Memorandum to File

Project: 34 Hutchins Drive
Engineering Peer Review – Memorandum #1

Date: July 24, 2006

L1.0

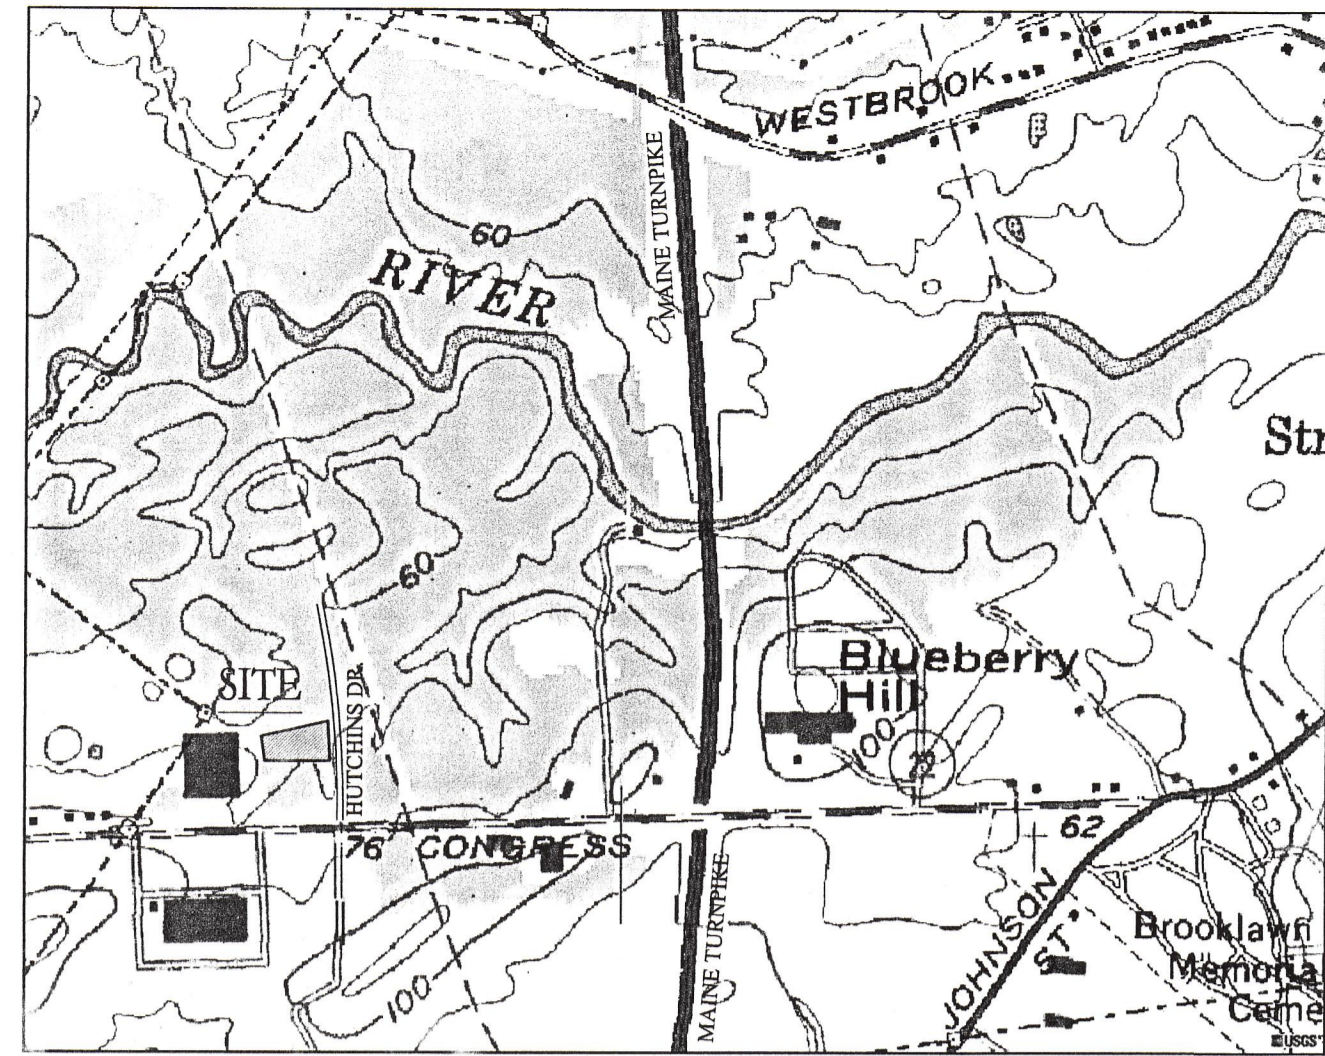
In addition to providing the Standard Boundary Survey, it would appear that the applicant should provide updated topographic information. The Applicant references existing Public Works information as the source for the topography, but based on our site visit, the following deficiencies were noted:

- a. No utilities are shown within Hutchins Drive
 - b. No information is shown on the location or elevation of the sanitary sewer line that bisects the site. It is noted that a review of the City Tax Map appears to include a note that the sewer wasn't installed within the easement, which should be verified.

- c. A CMP culvert which appears to cross the sewer easement is not shown.
 - d. A drainage course which appears to originate from the parking lot of Map 238A, Lot B-1 (2385 Congress Street Associates LLC) is not shown.

Dwg. No. L2.0

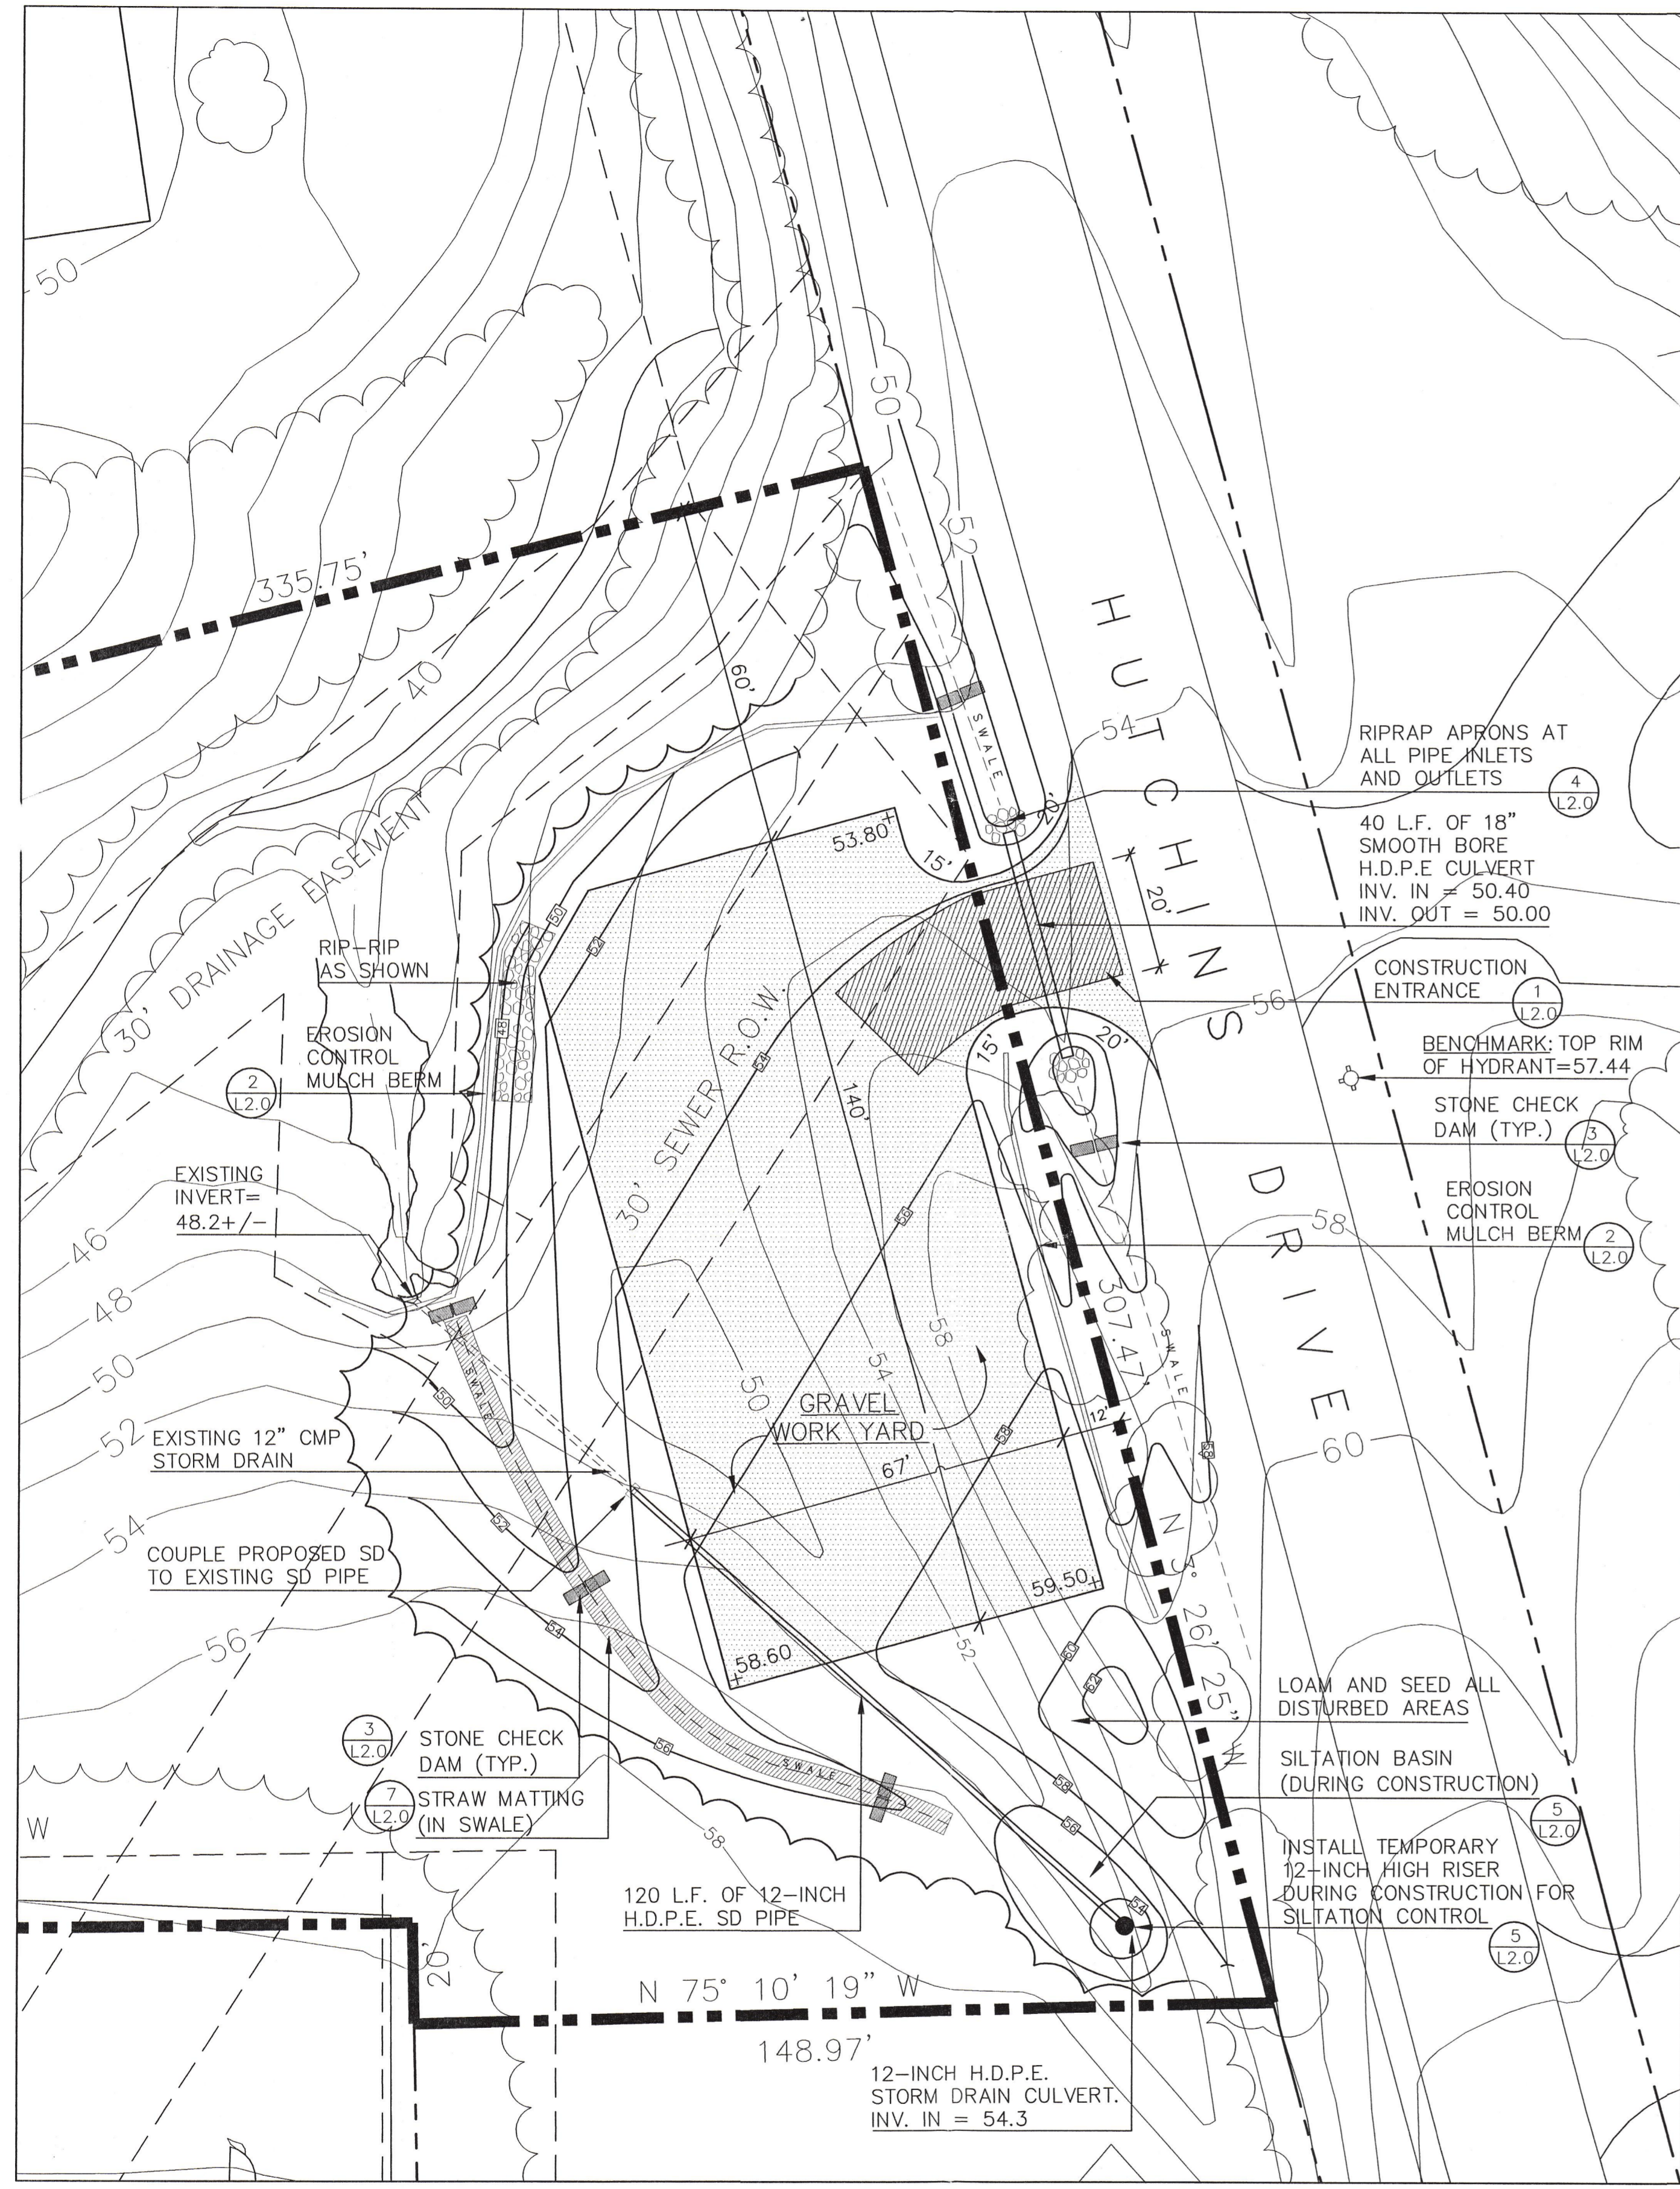
5. Demonstration that the proposed improvements will not negatively affect the existing sewer main or the rights of the City under the easement. Within the proposed "gravel work yard" the Applicant is proposing to modify the elevations by cutting up to at least 1 foot and filling up to at least 3 feet. In the proposed swale, the Applicant is proposing to cut between 2 and 2.5 feet within the easement.

10. While the Applicant is correct that under the City Ordinances due to the size of the project formal stormwater treatment measures are not required, it does not appear to be warranted to have a gravel parking lot sheet flow to within 40' of a stream. Alternate grading or treatment measures would appear to be available that would provide greater protection to the watercourse.

4 RIP-RAP APRON

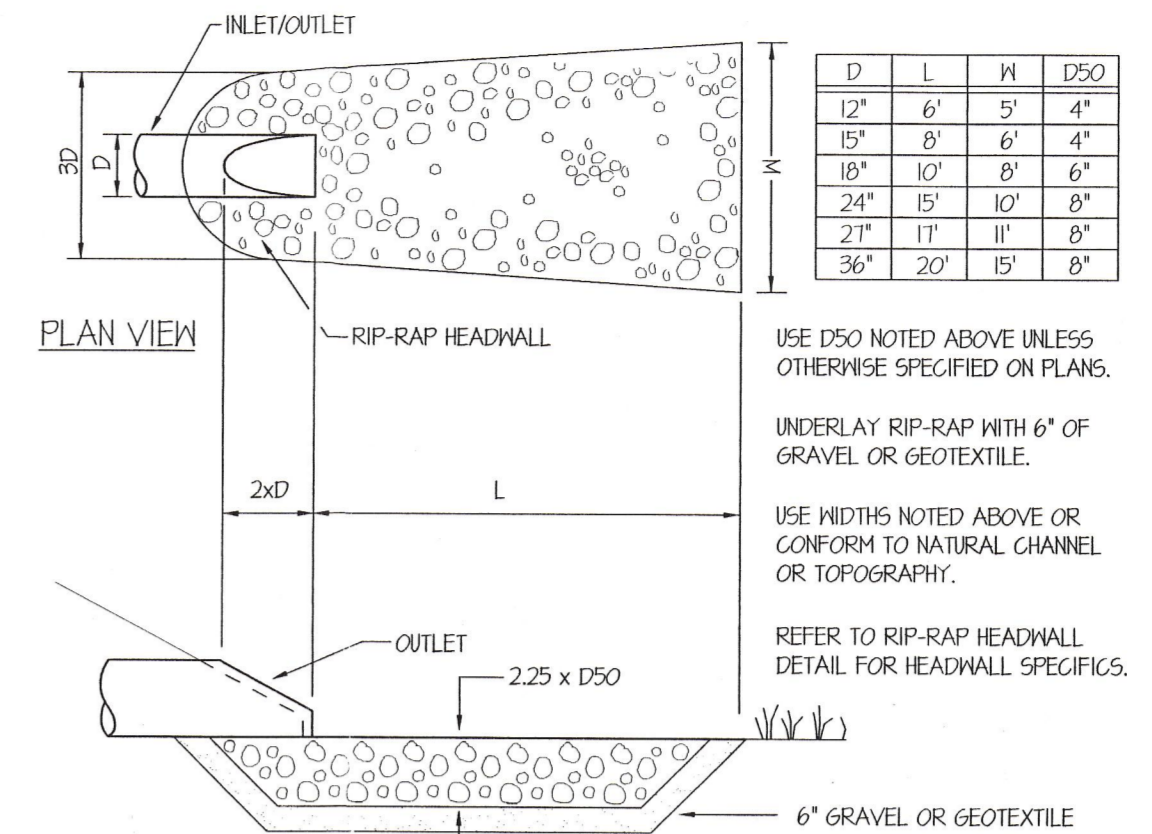
7. Details for the riprap slope.
 8. Pipe sizing calculations for the driveway culvert.
 9. All plans submitted should be stamped/signed by the professional responsible for their preparation.
